# Derrygreenagh Power Submission

**File No:**  
319023 (SID Application)

**Applicant**  
Board na Mona  
(Derrygreenagh Power)

**Description**  
Combined Cycle Gas Turbine and Open Cycle Gas Turbine Thermal Power Plant, Electricity Grid Connection including 2 no. substations, and associated buildings, plant, site works, service and ancillary development.

TITLE:
**PROPOSED DEVELOPMENT - OVERVIEW PLAN
(SHEET 1 OF 8)**

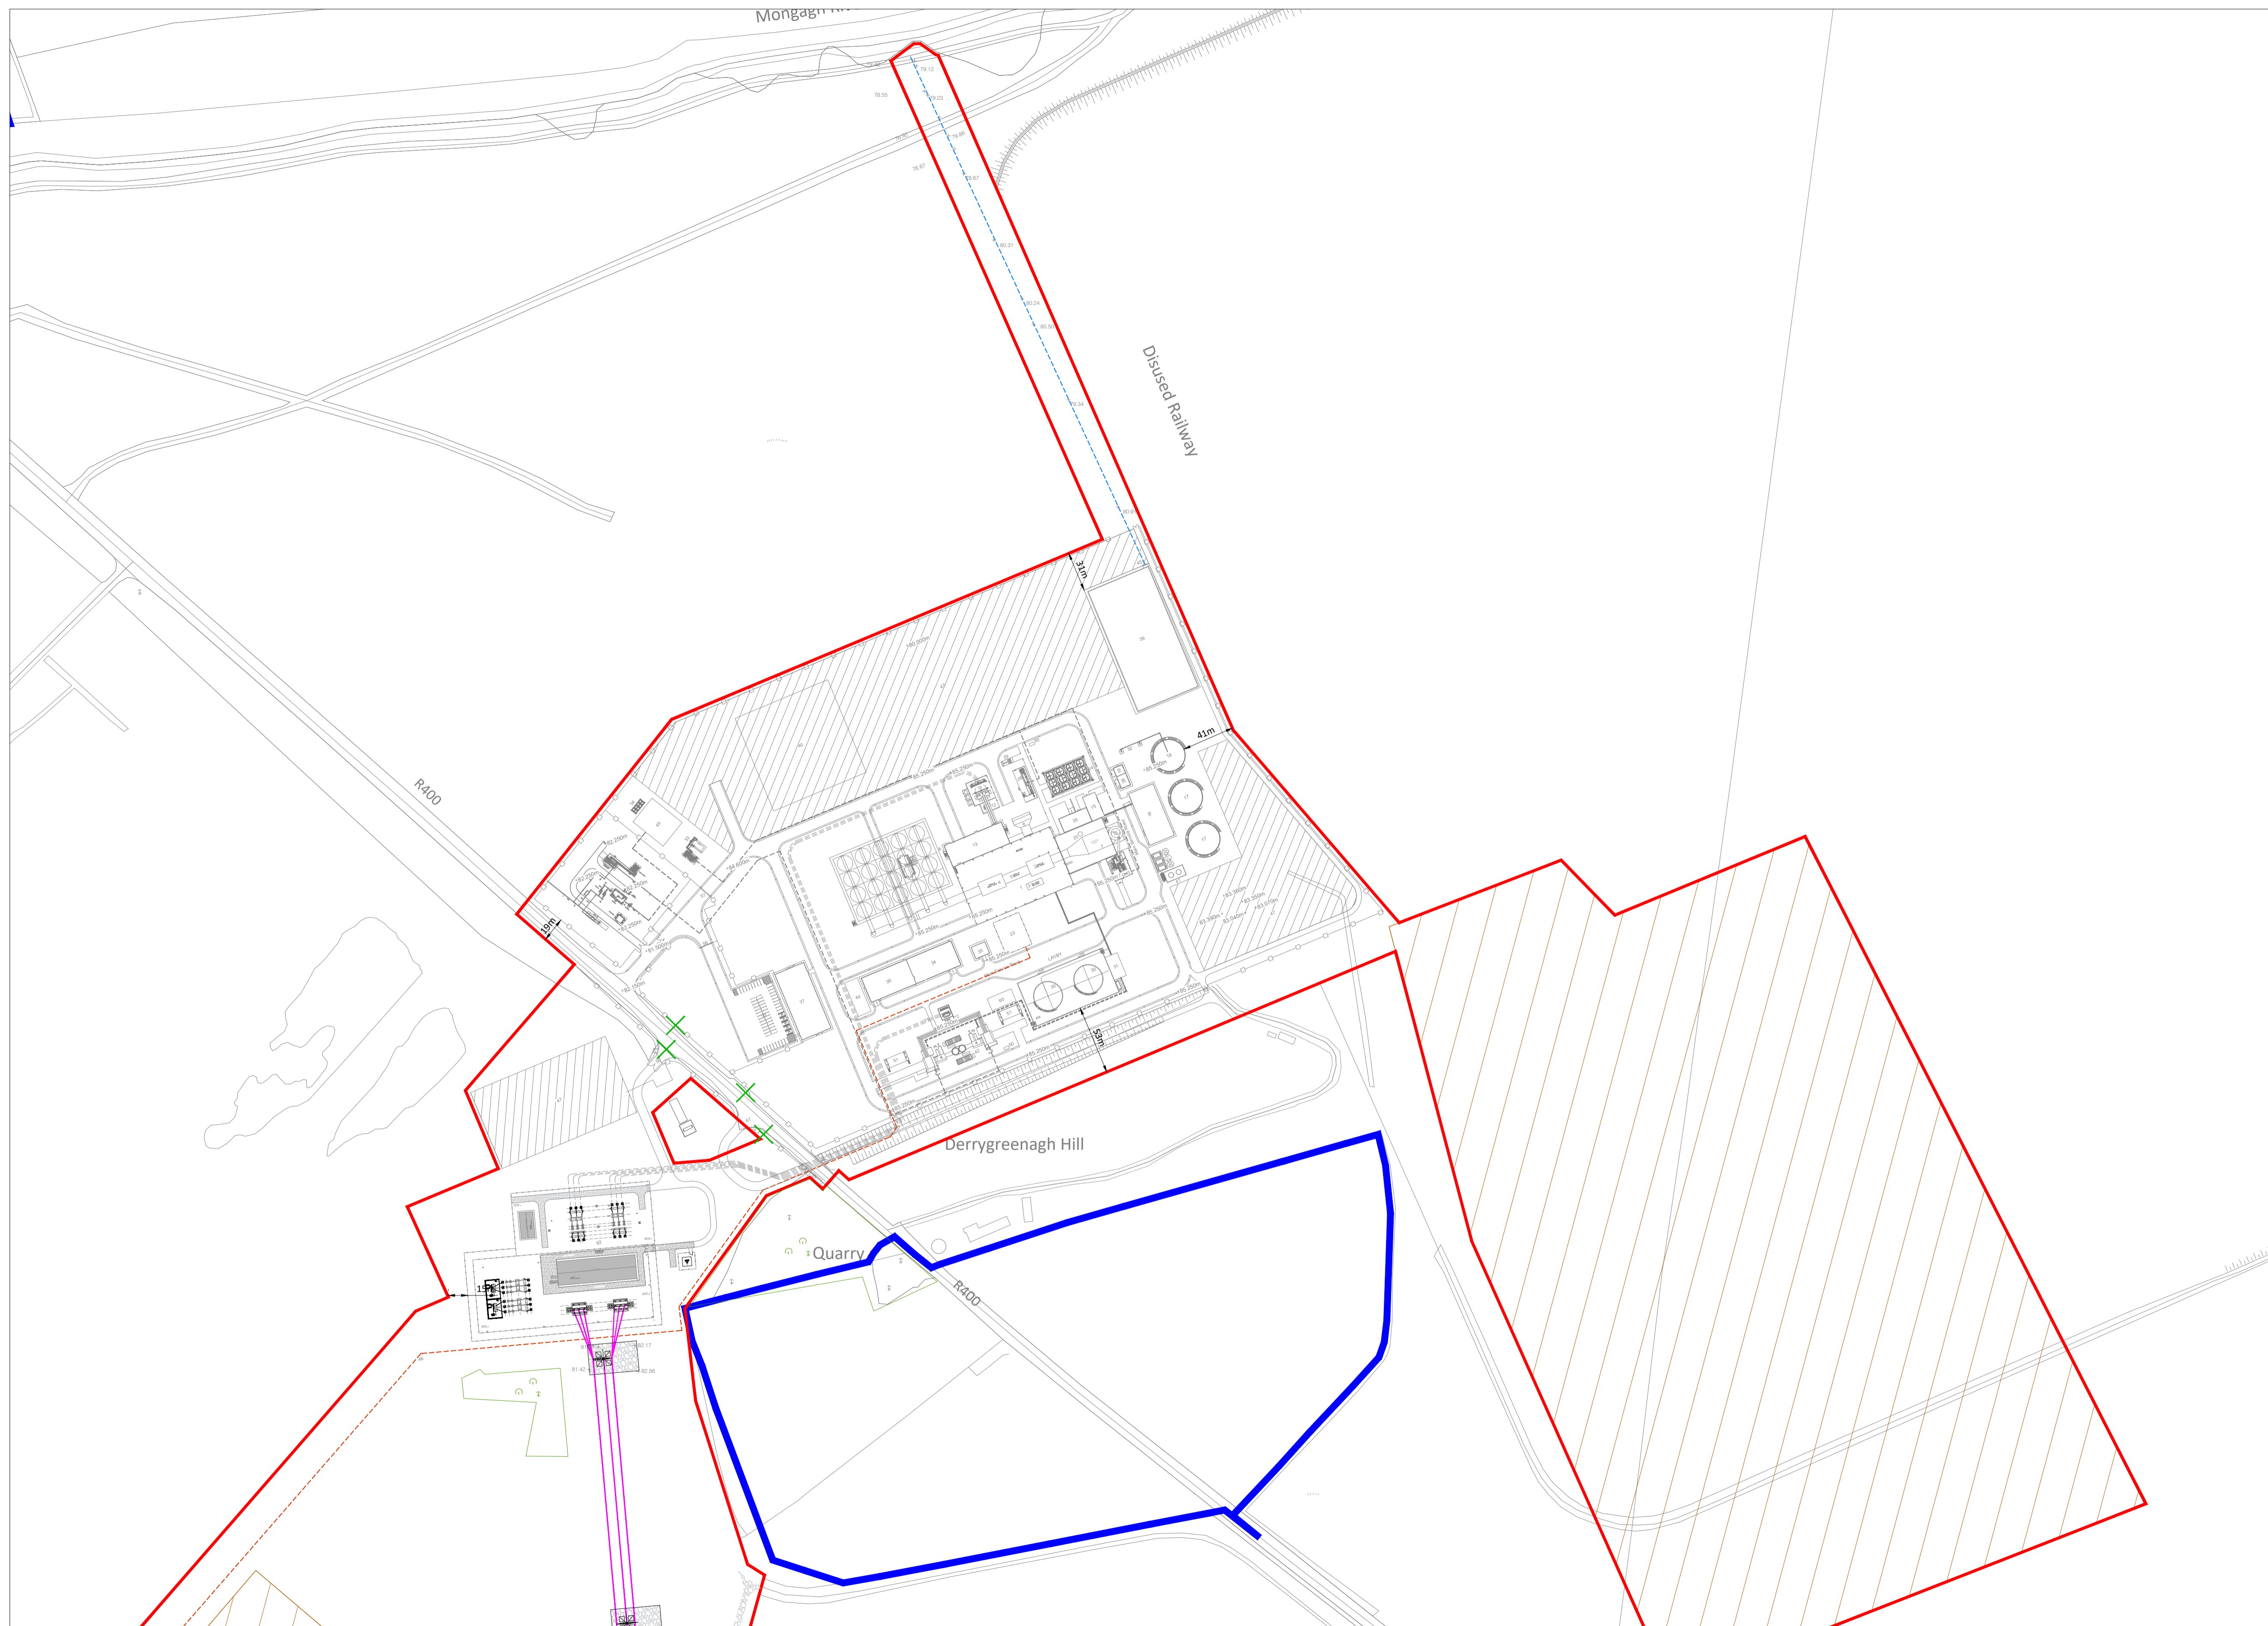
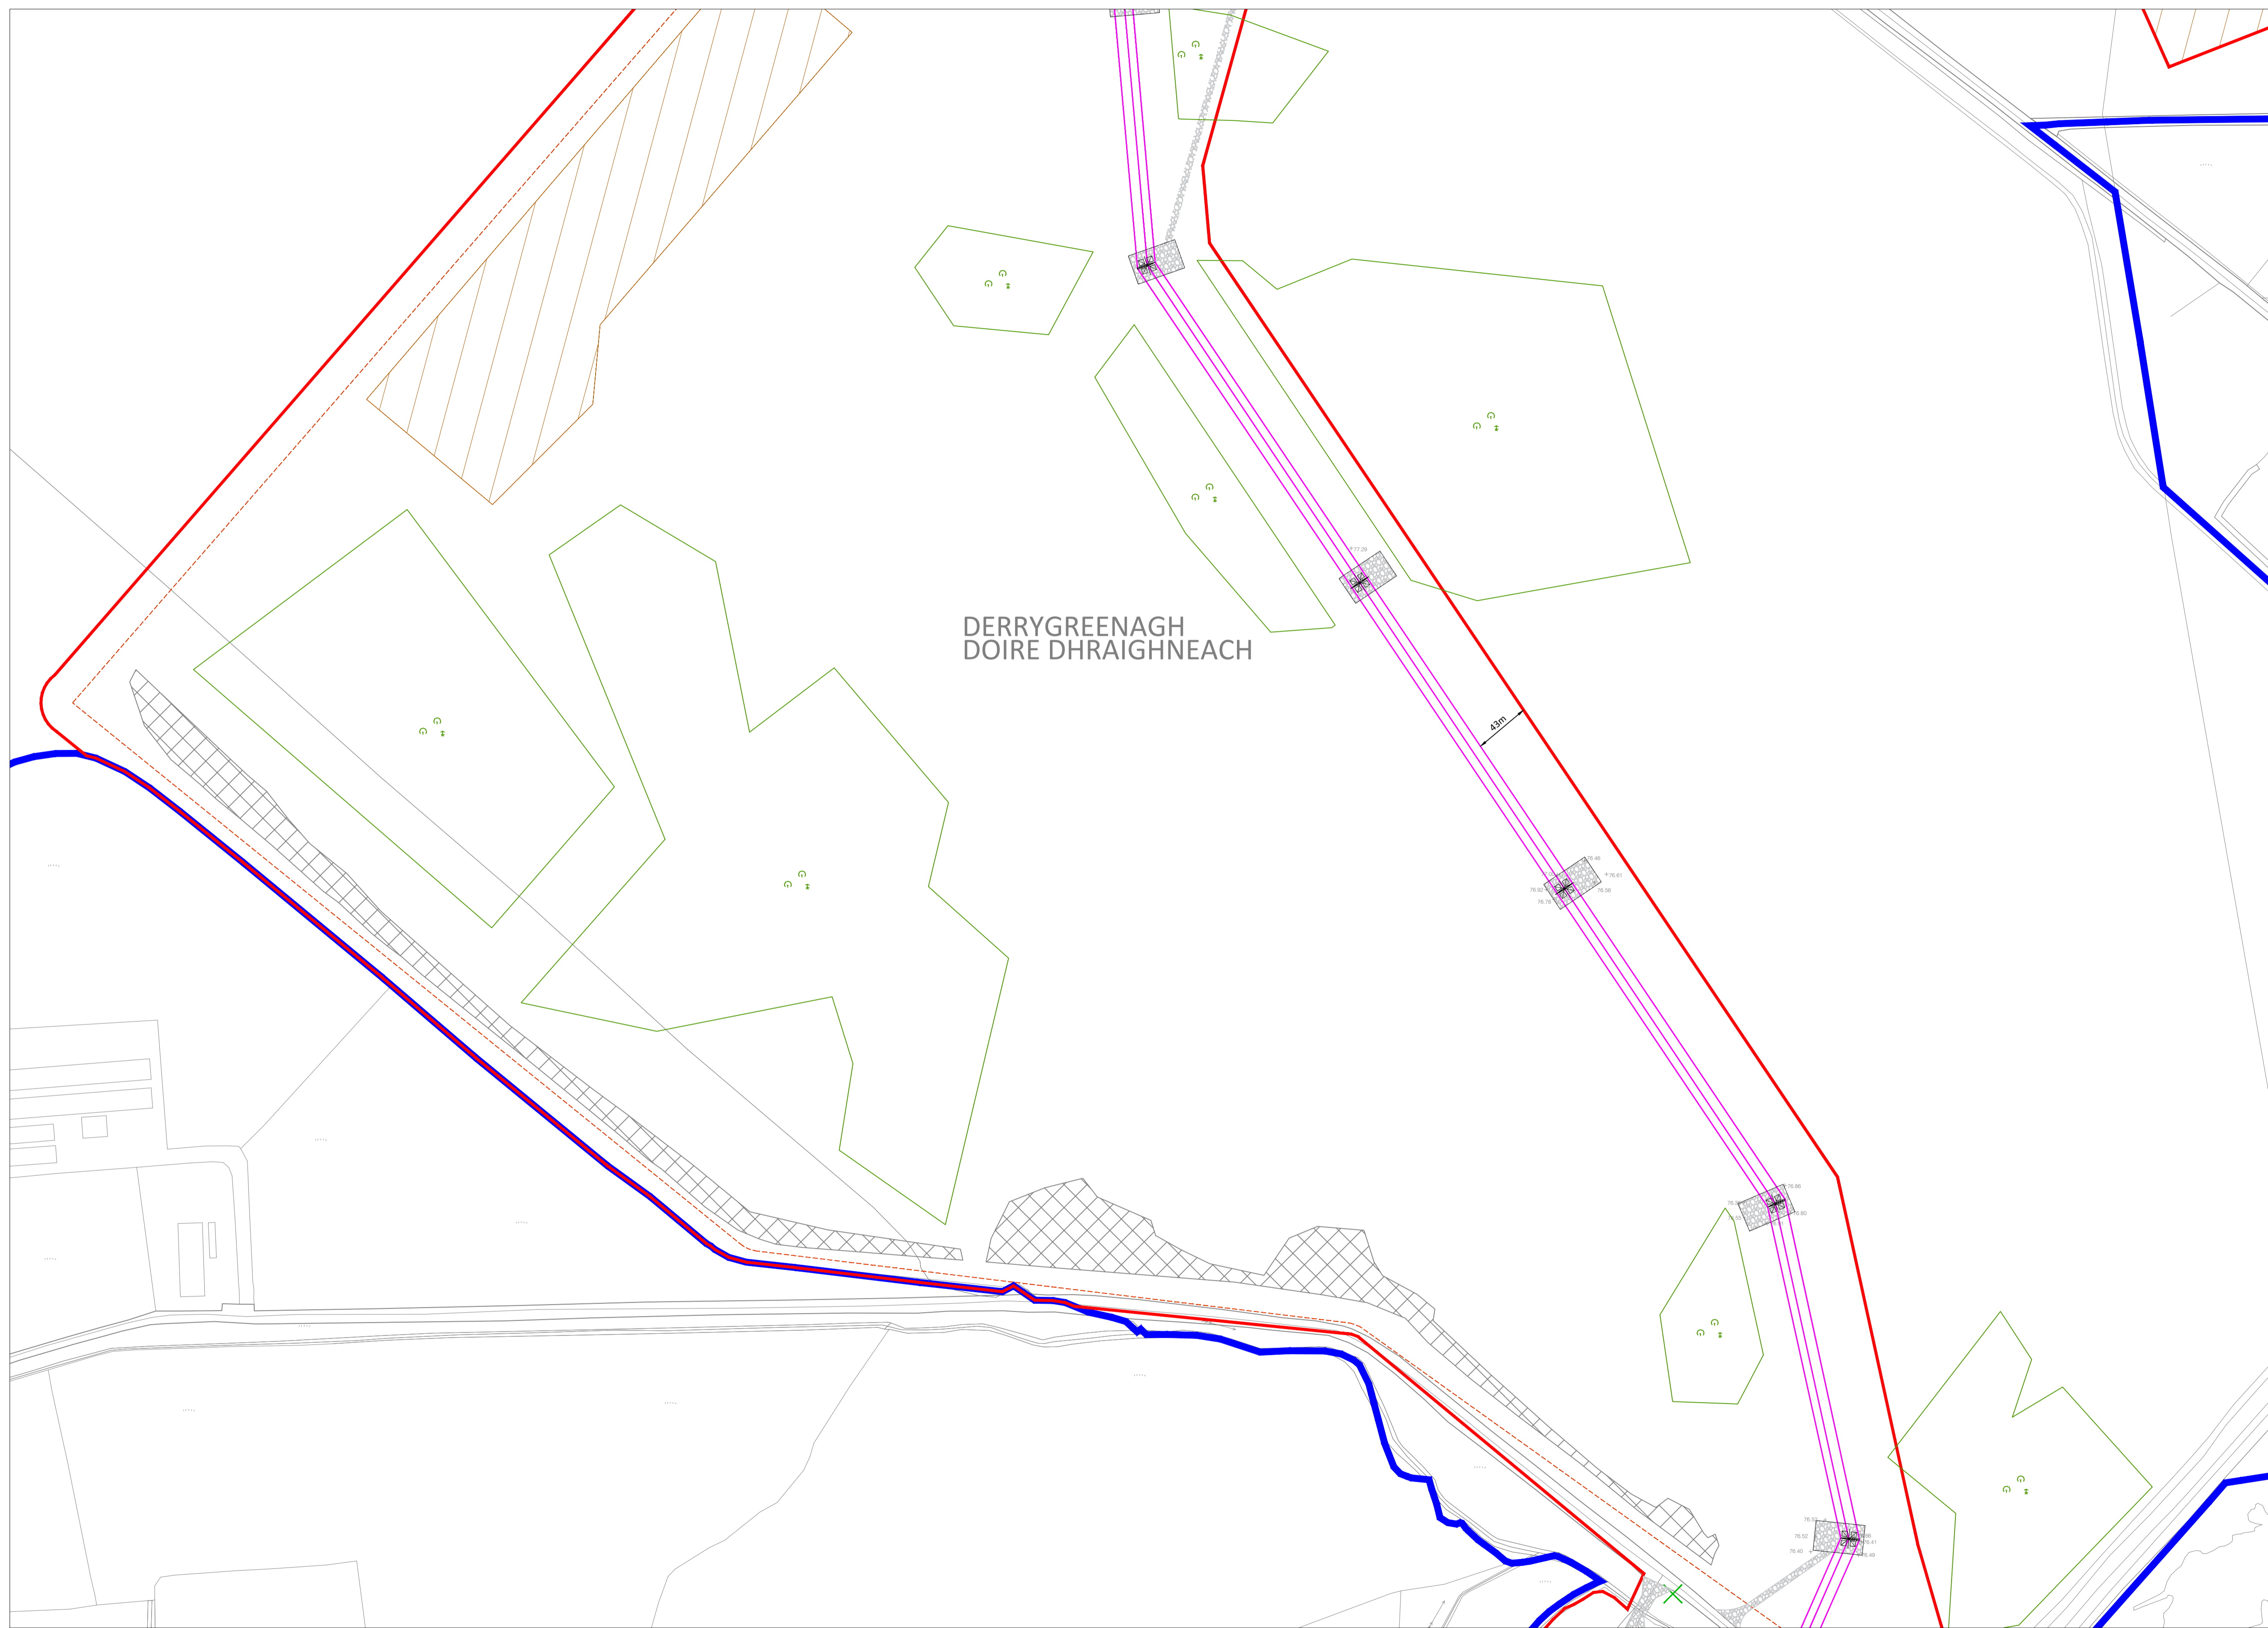
1. The cabling connecting this development to the substation be located entirely underground with no **overhead wires/pylons permitted**.

The proposed cable way will have a major visual impact on the surrounding countryside. This imposition can be overcome by undergrounding the entire cable way from Derrygreenagh to Tubberdaly.

The red outline below shows that the development boundaries of this development extend beyond the site of the Power Station building itself. There are no houses located within 1km of the Power Station Building, but homes located next to cable routes and substations should qualify for a near neighbour payment as they are equally as affected.
